From: Speakman, Glenn - Oxfordshire County Council
Sent: 04 March 2022 15:37
To: James Kirkham; DC Support
Cc: Transport CDC Minor; Cllr George Reynolds
Subject: 21/00922/OUT Land West Of, Foxden Way, Great Bourton, OX17 1QY

Planning application:	21/00922/OUT
Location:	Land West Of, Foxden Way, Great Bourton, OX17 1QY
Description:	OUTLINE Planning Application with all matters reserved save for access for up to 9 First Homes
Case Officer:	James Kirkham

TITLE
PROPOSED SITE ACCESS JUNCTION WITH VISIBILITY SPLAYS

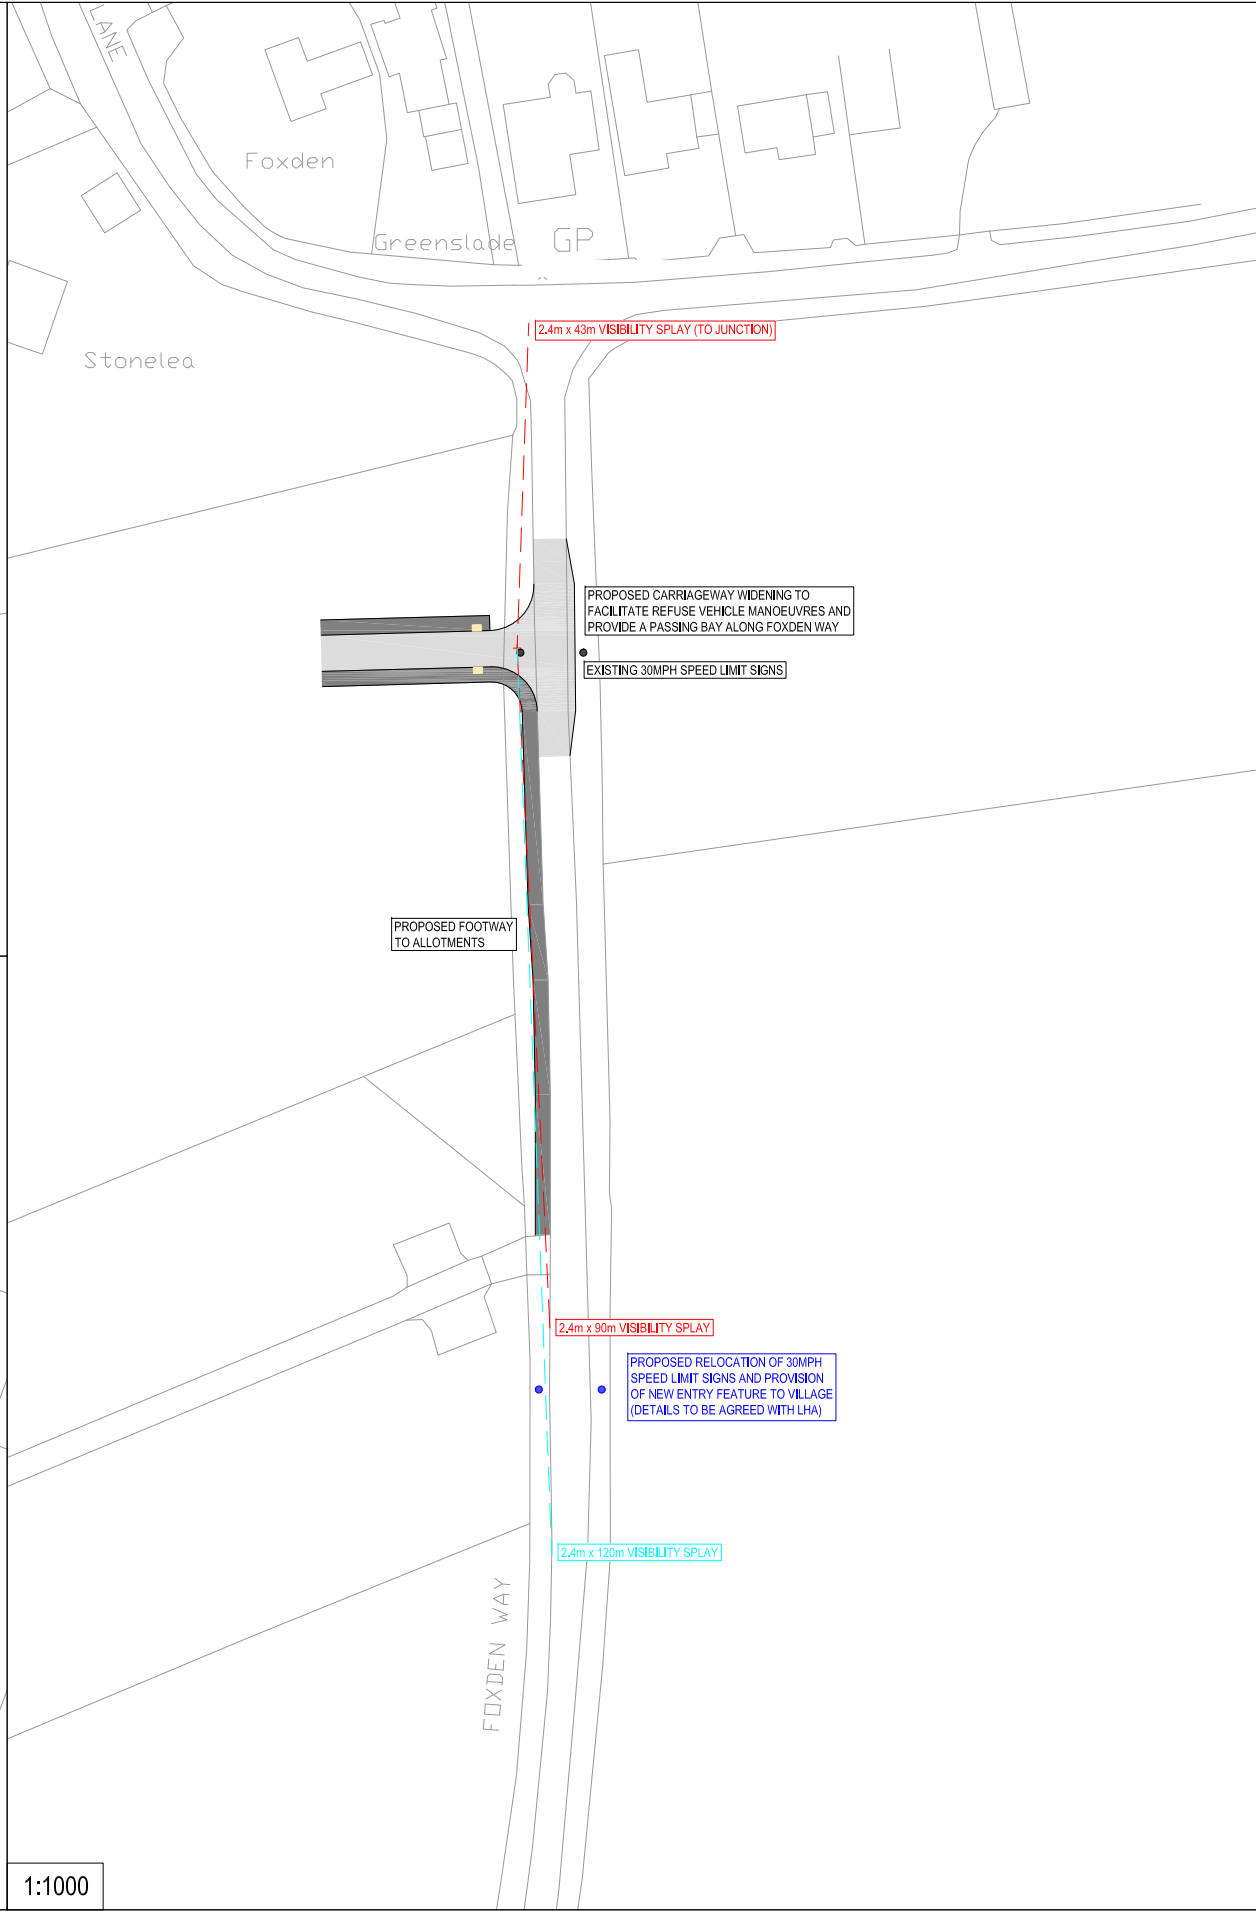
Vision splay calculation: The vision splays are considered acceptable. The northern splay can demonstrate visibility reaching the school lane junction. The southern splay is shown as 90m but it is clear that a longer splay is attainable as set out in the transport note. The relocation of the 30mph road signs will require a consultation.

PROJECT NO.	DRAWING NO.	REV
T21512	002	C

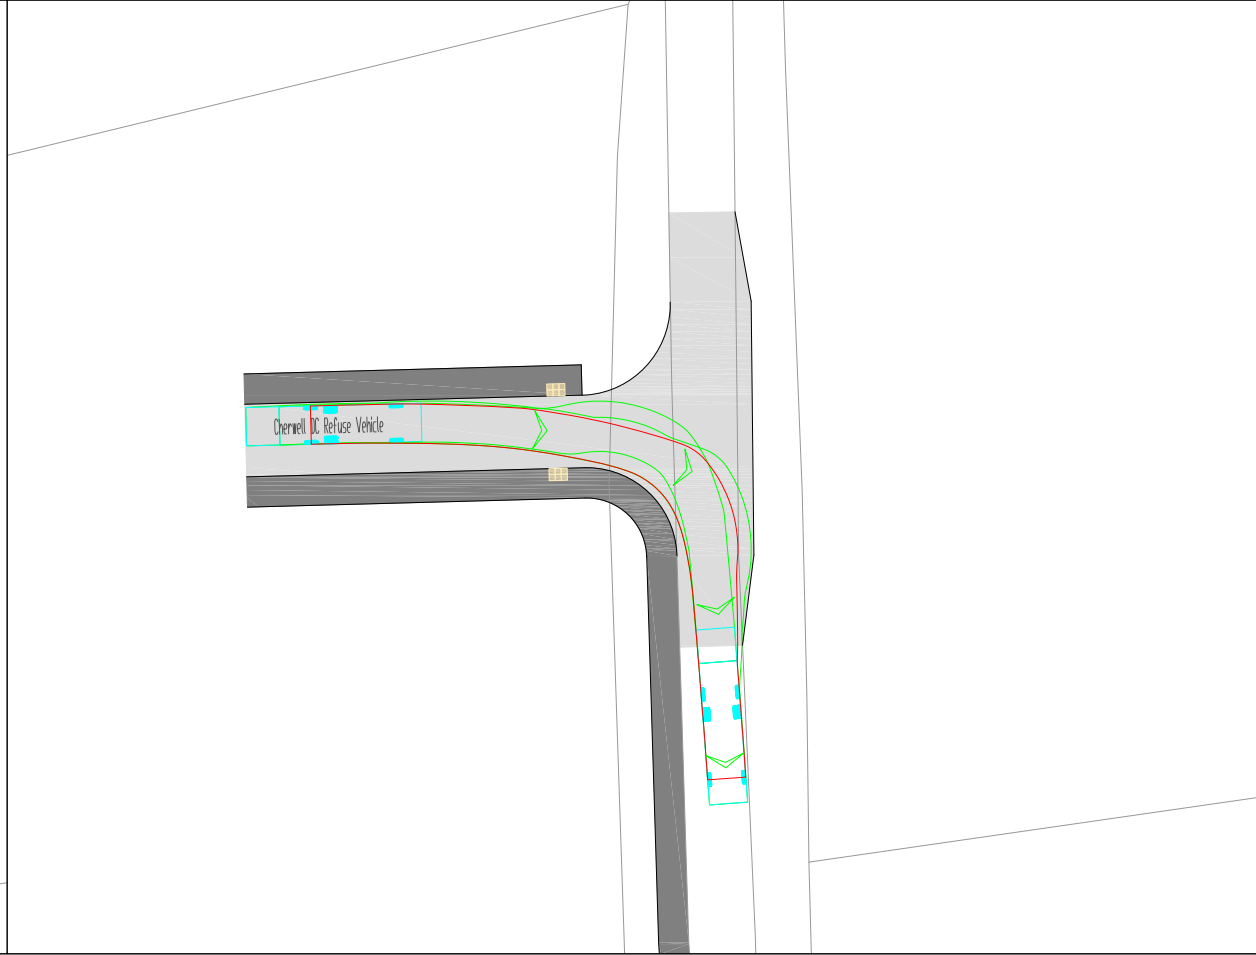
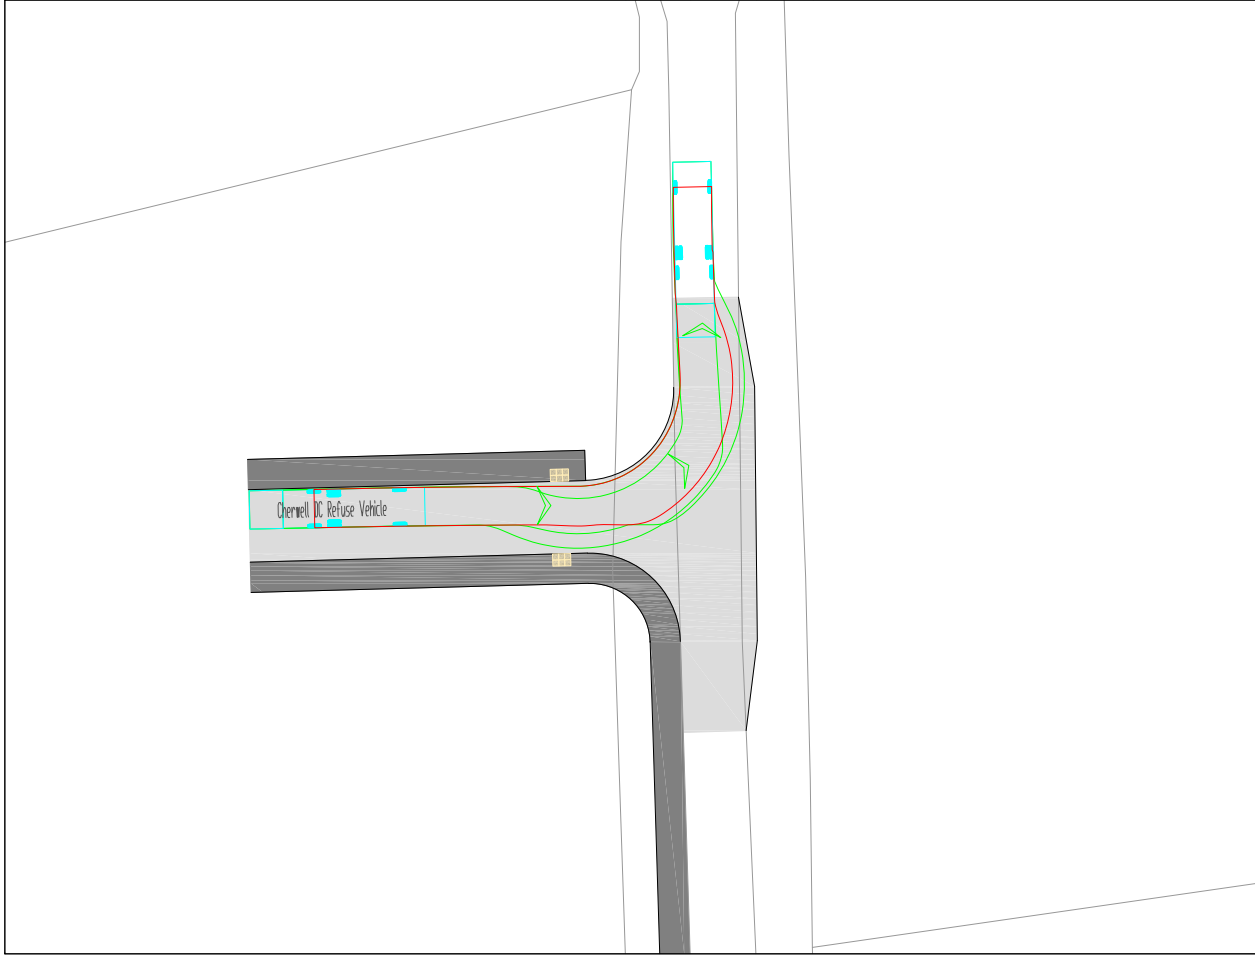
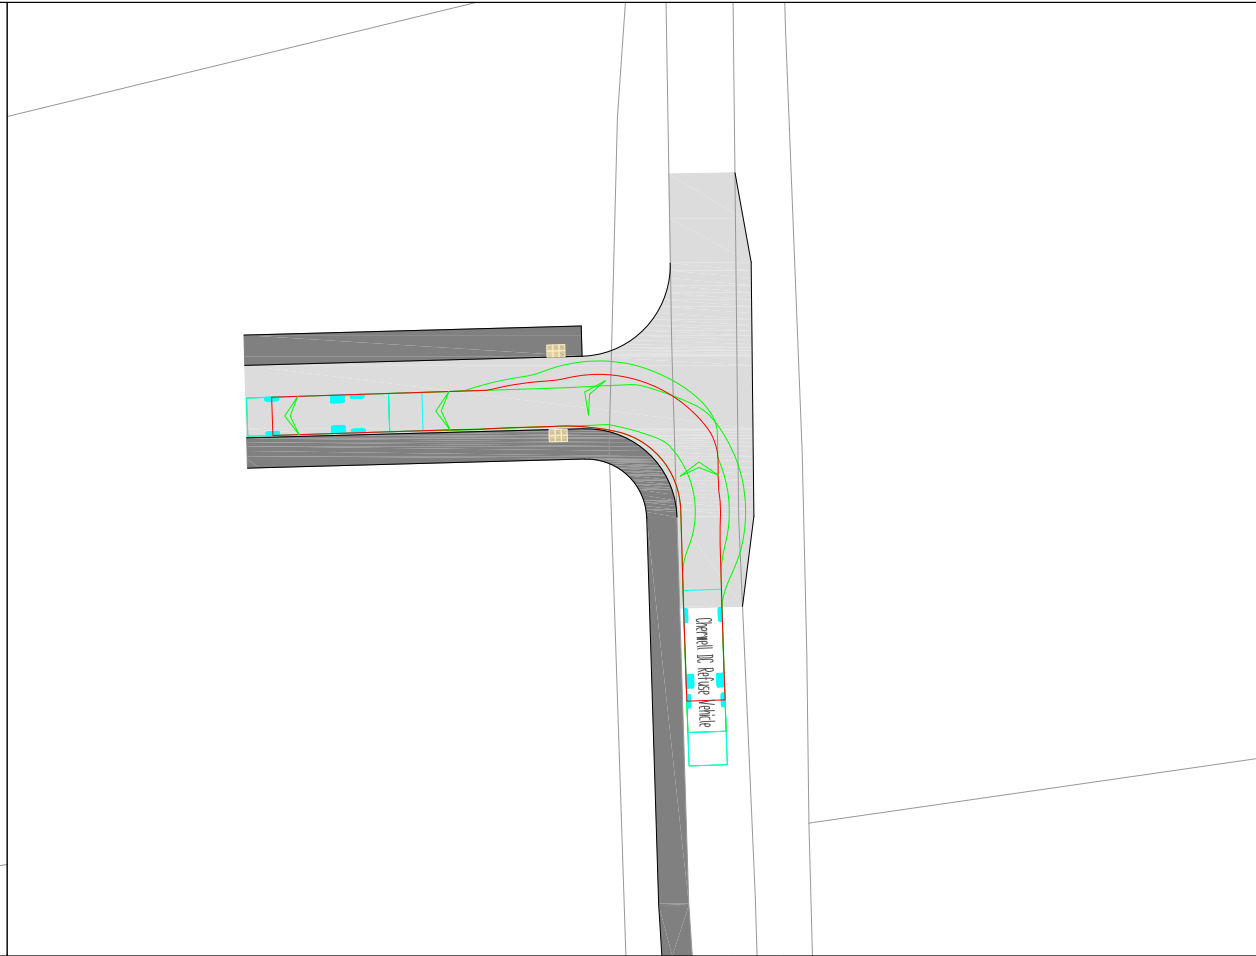
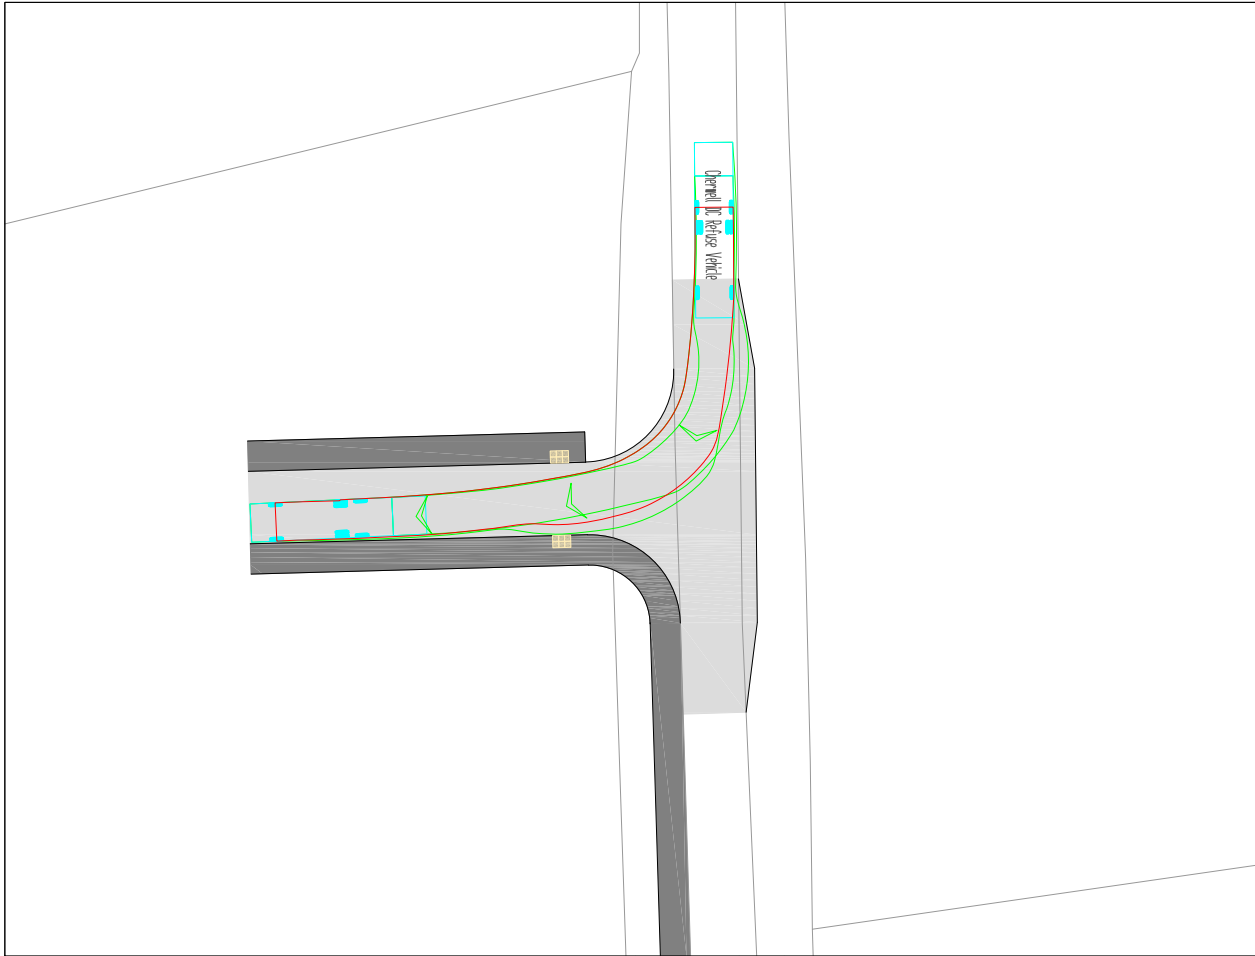
Swept path analysis: The updated swept path analysis shows an 11.6m long refuse vehicle successfully accessing and egressing from the site via the proposed vehicular access in a forward gear.

Vehicle overrun: This issue will be solved by the localised widening of Foxden Way at the proposed site access.

REV	DESCRIPTION	DATE	BY	AUTH
B	FOOTPATH ALIGNMENT REVISED TO MEET CLIENT REQUIREMENTS	12.01.22	JP	GM
A	ACCESS UPDATED FOLLOWING UPDATE TO MASTERPLAN	18.10.21	JP	GM

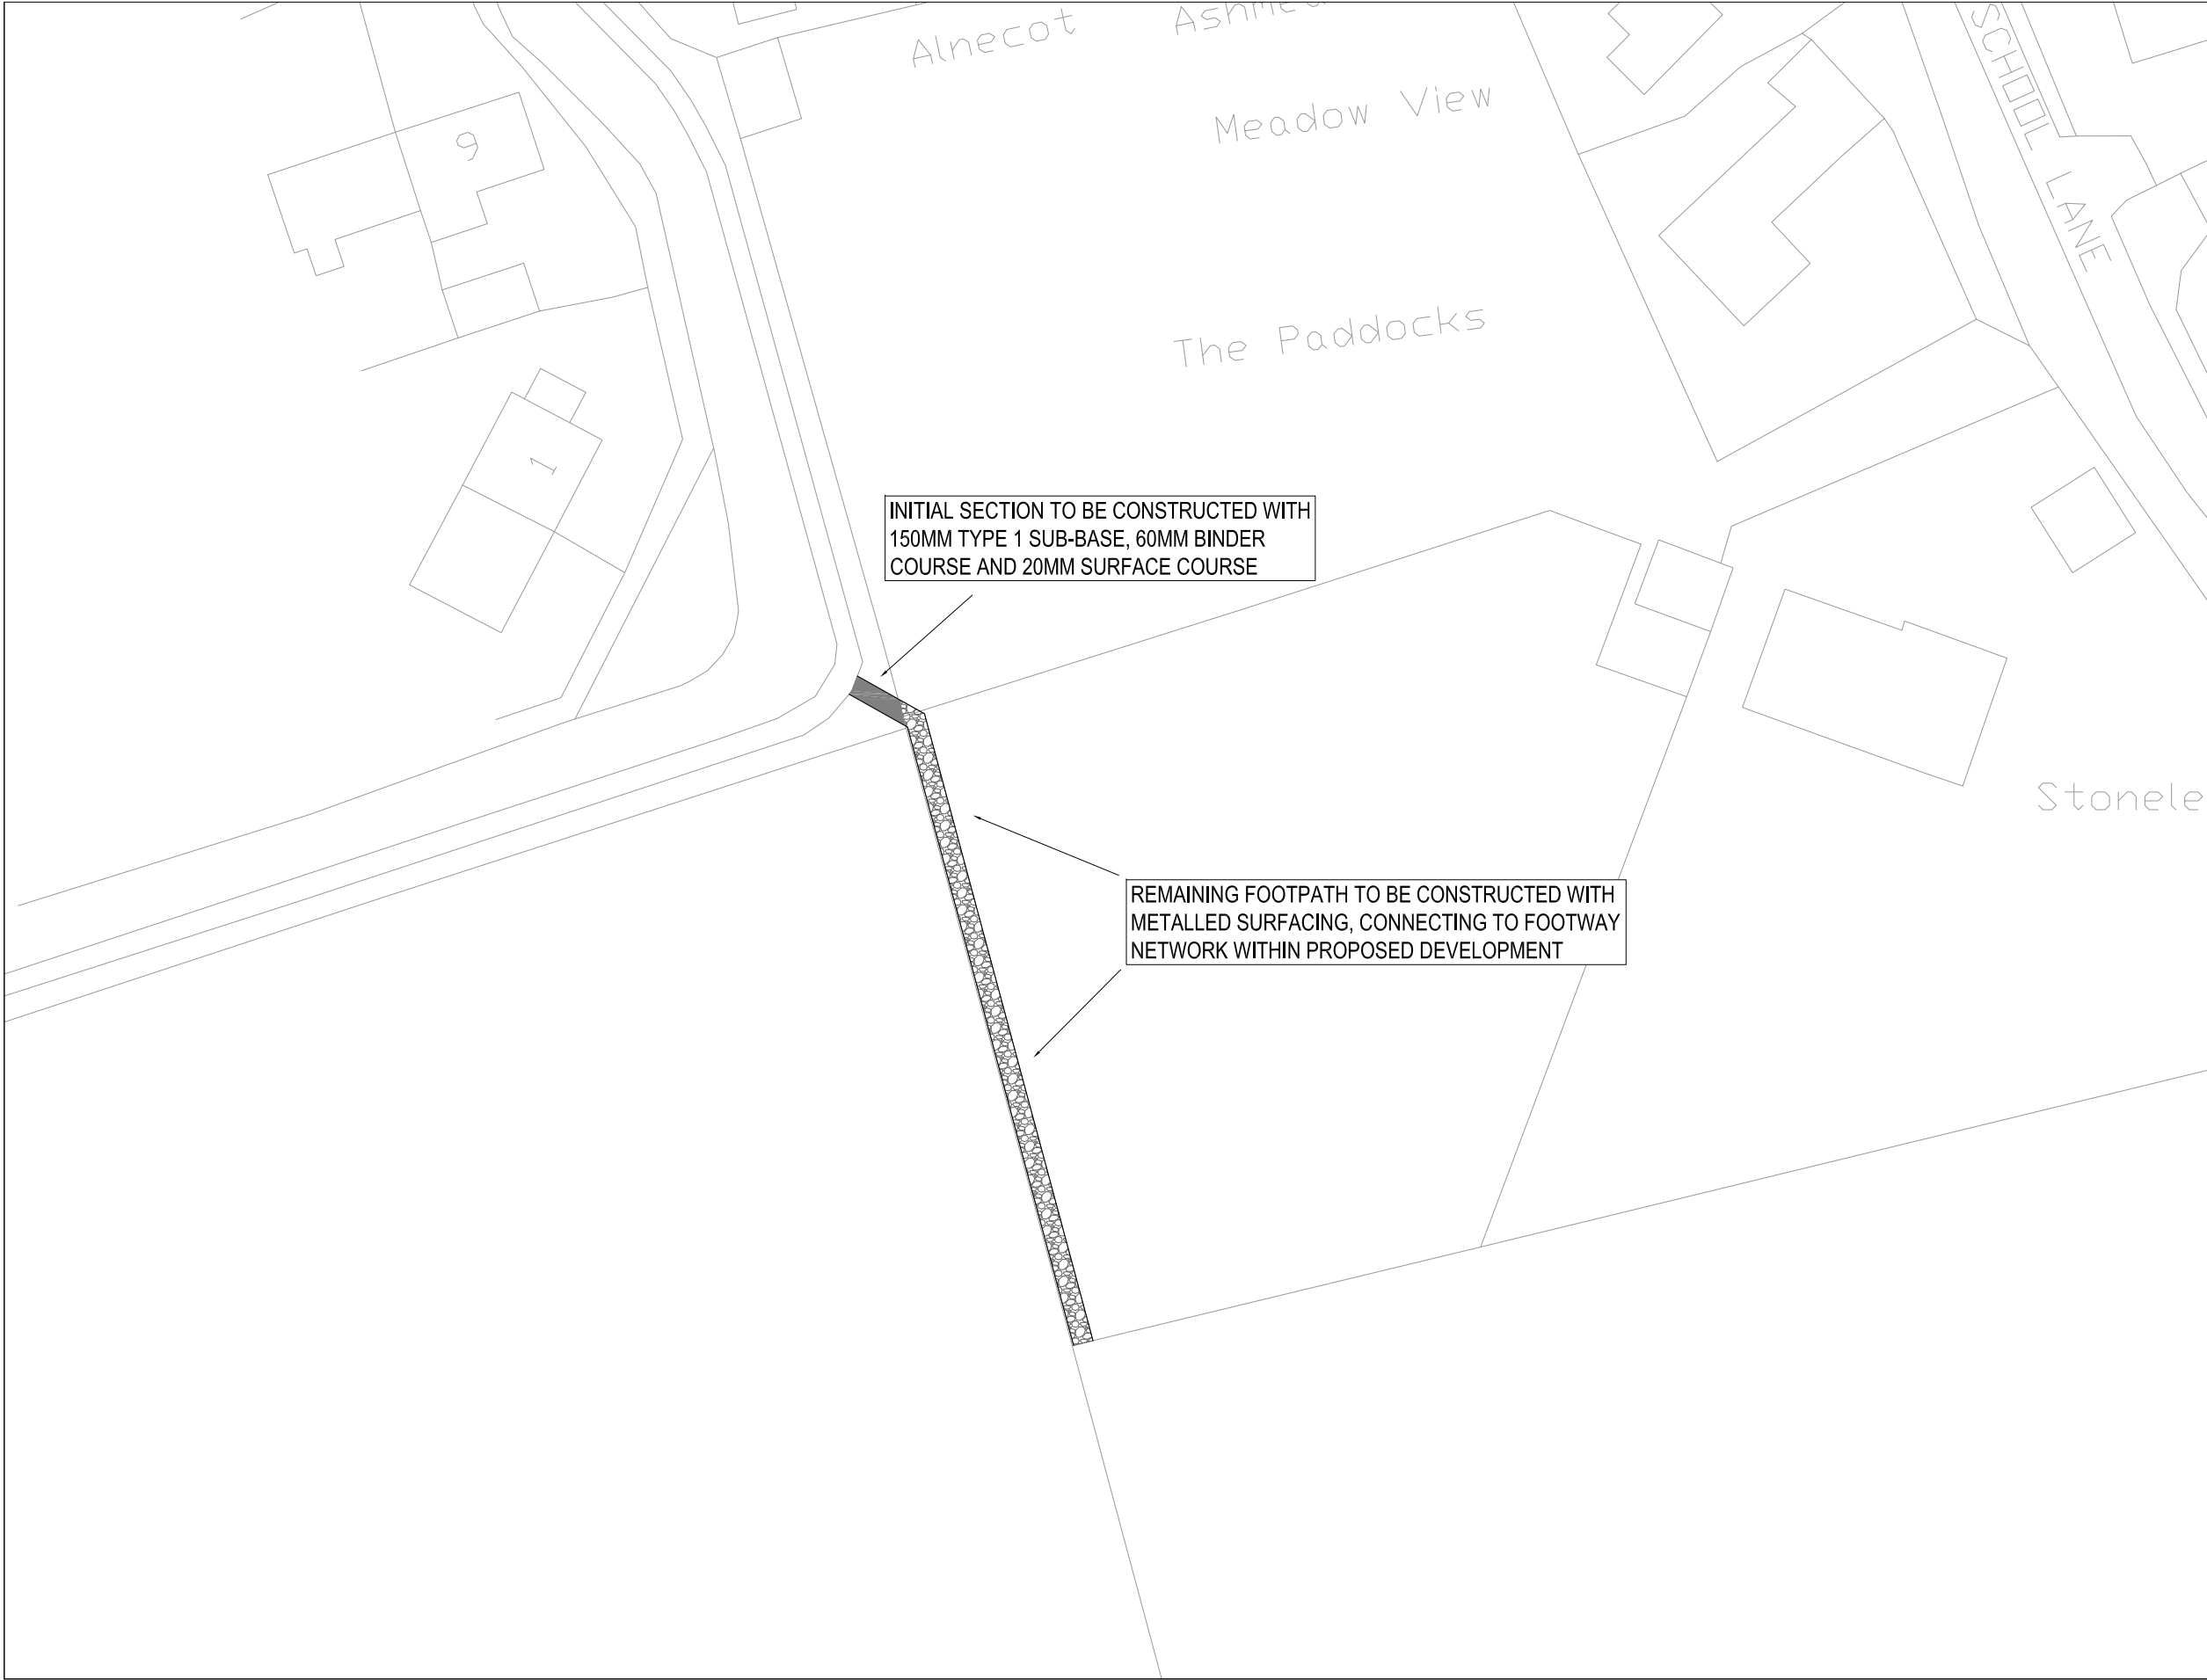
Pedestrian access: The previous plans made no provision for additional pedestrian infrastructure. The new plans propose a 2m wide footpath connecting the site to the southern allotments via Foxden Way. An additional pedestrian link is also proposed connecting the rear of the site to South View.

The new link to South View should be 2m in width and of materials suitable for vulnerable road users such as those using prams, wheelchairs, etc. If a 2m width is not achievable, further details should be provided demonstrating that the new path isn't bordered by obstacles such as fences or hedgerows. This should be obtained via planning condition.
